Some further updates on the conditions (developer's responses in green, 13/04/26):

Condition 10 (CEMP) – I have not managed to obtain formal comments from KC Highways – however I discussed it informally with a Highway officer yesterday. His conclusion was that the plan is largely satisfactory. We just need confirmation of the following points, which do not seem to have been included in the submitted details:

Means of Access

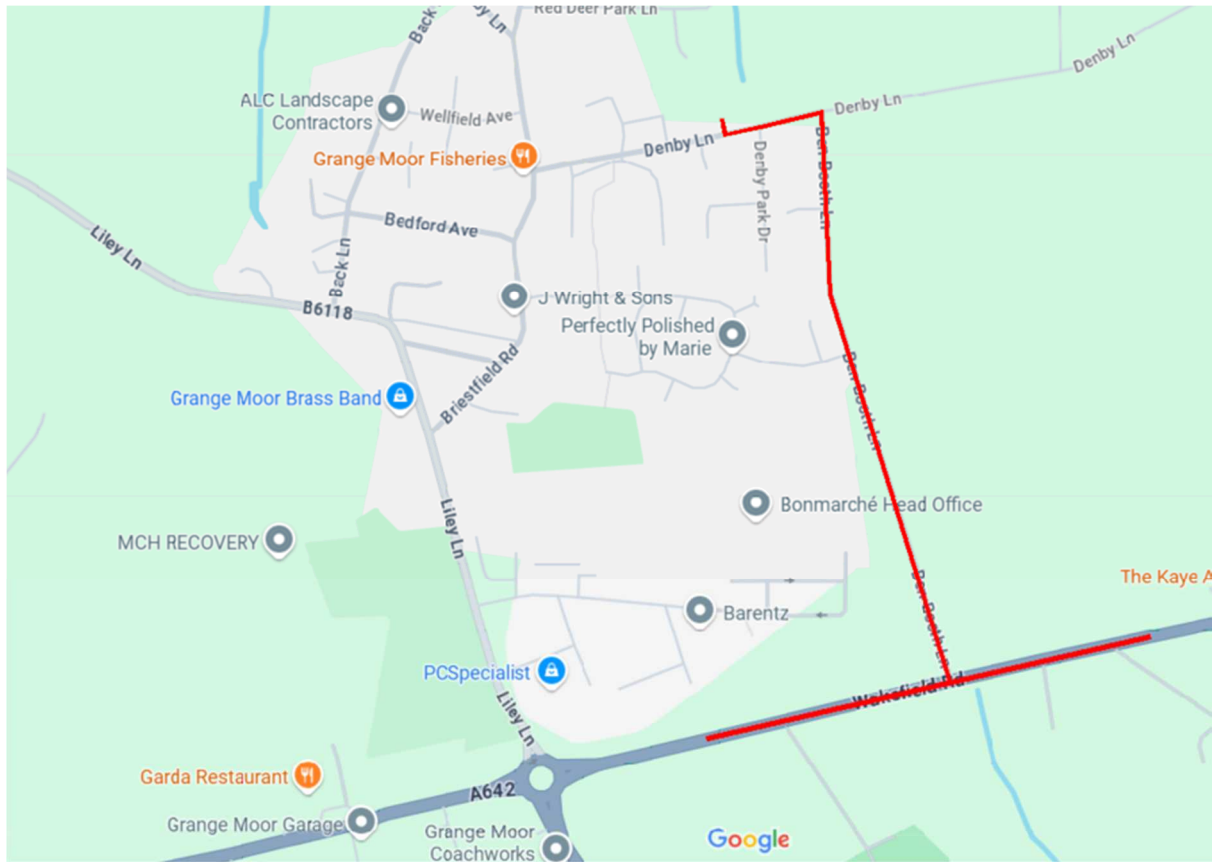
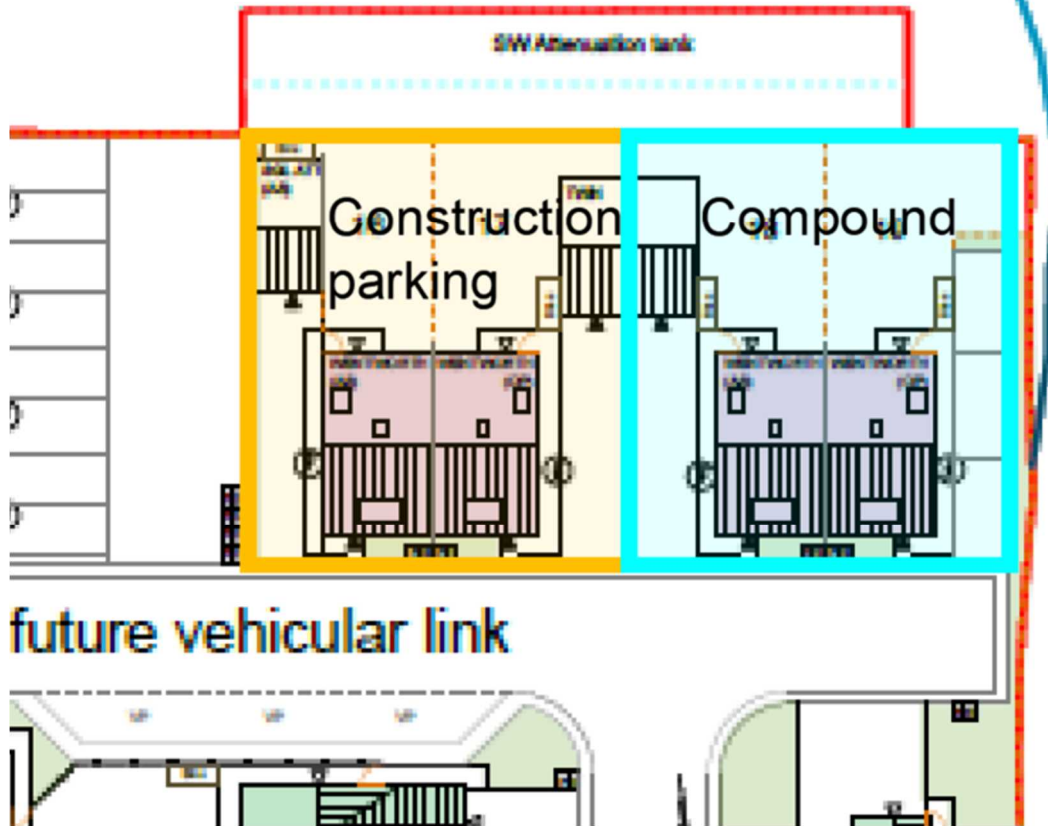
- Timetable of works (I know you have already started construction) **now until End of 2027.**
- Numbers of construction vehicle movements **20/day**
- Location of HGV waiting area(s) **HGVs are to wait on the road within our site.**
- Storage of plant and materials (is this to be in the light blue area labelled "Compound", or in a separate area?) **Yes, this is within the compound area.**
- Signage. **There is signage to direct traffic to site at junction with Bristfield Road/Denby Lane and again on Denby lane at the junction with our site entrance.**
- Site waste management, including details of recycling/disposing of waste resulting from construction works. **Our site waste is collected from our skips by a recycling company and sorted off site to be recycled.**
